At a meeting of Barnham and Eastergate Parish Council Planning and Environment Committee held on 21 June 2022, the Committee re-considered this application following the clarification of some matters relating to this planning application.

Application No: BN/48/22/PL

Site Address: Stoneyfield Cottages Eastergate Lane Eastergate PO20 3SL

Description of Works: Variation of condition imposed under BN/112/21/PL relating to condition 2-plans condition.

FOR MR & MRS MITCHELL		
SITE SITE AT: STONEFIELD NURSERY, EASTERGATE LANE, EASTERGATE. PO20 3SL		
TITLE SITE PLAN SHOWING PROPOSED DWELLING		
SCALE 1:100 © A2	DATE 03/22	DRAWING NO. 01P REV C

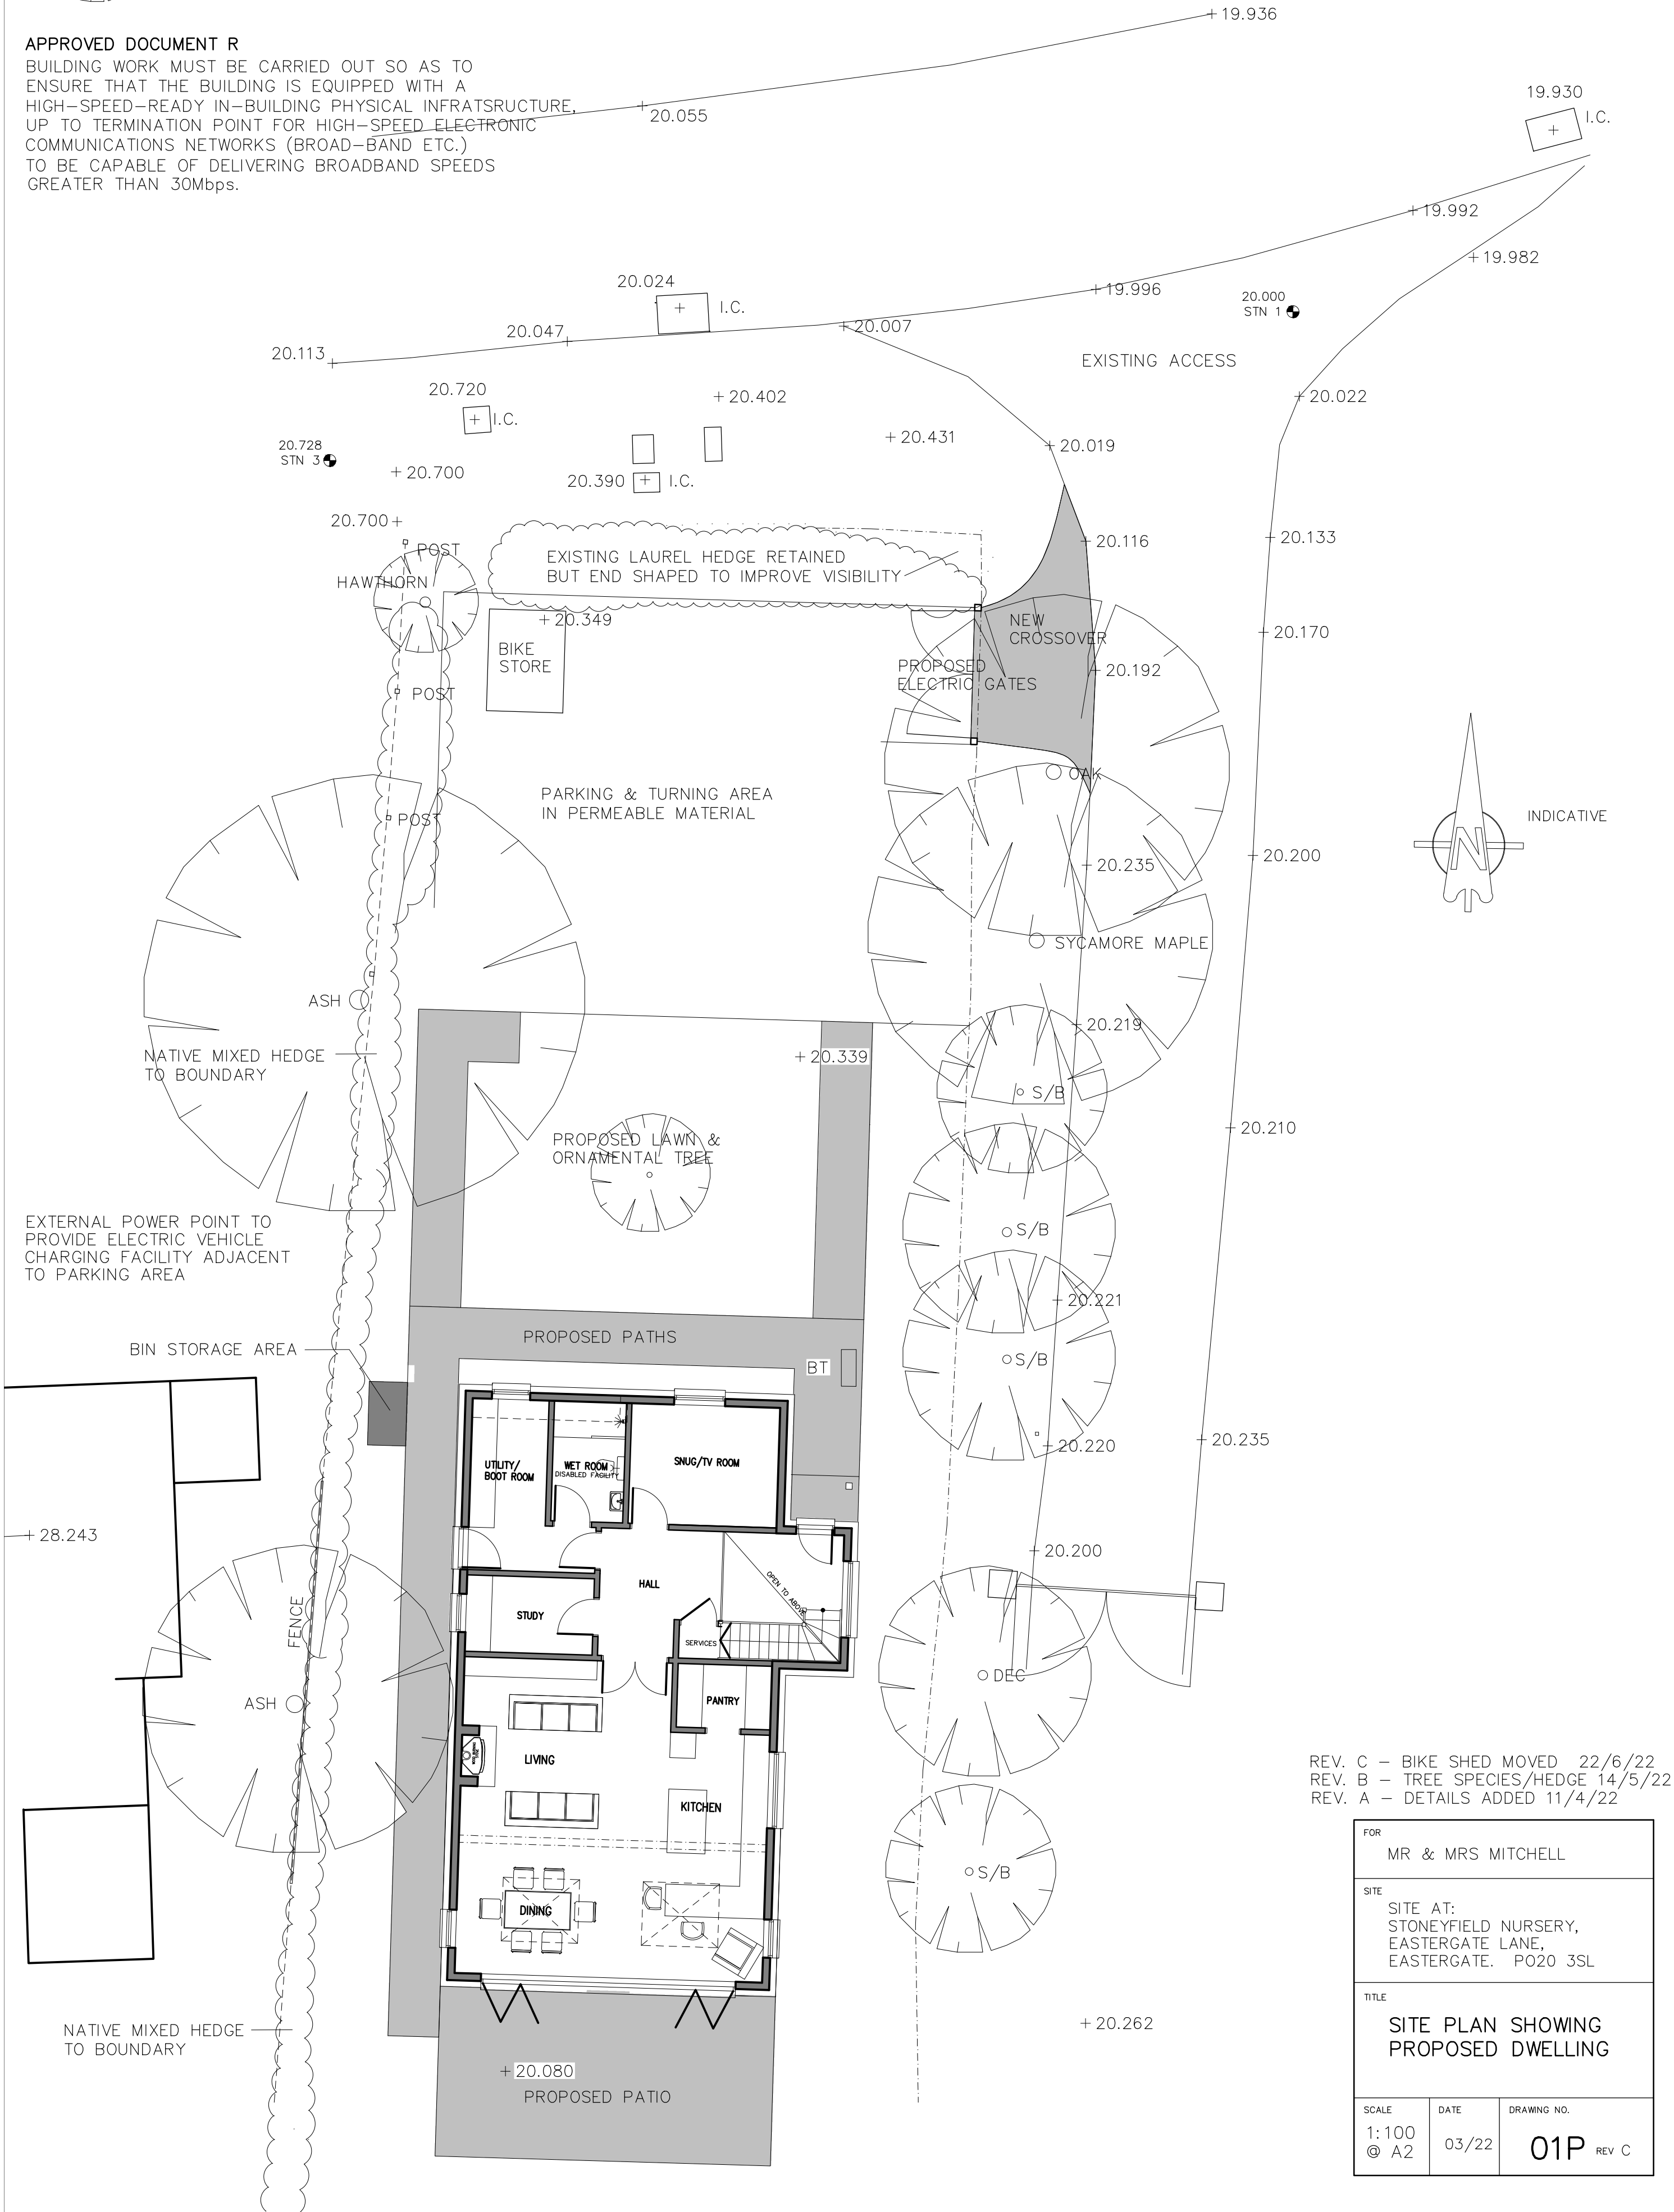
The Committee resolved to submit a no objection providing that the plans that were due to be submitted show that the bike store is to be relocated.
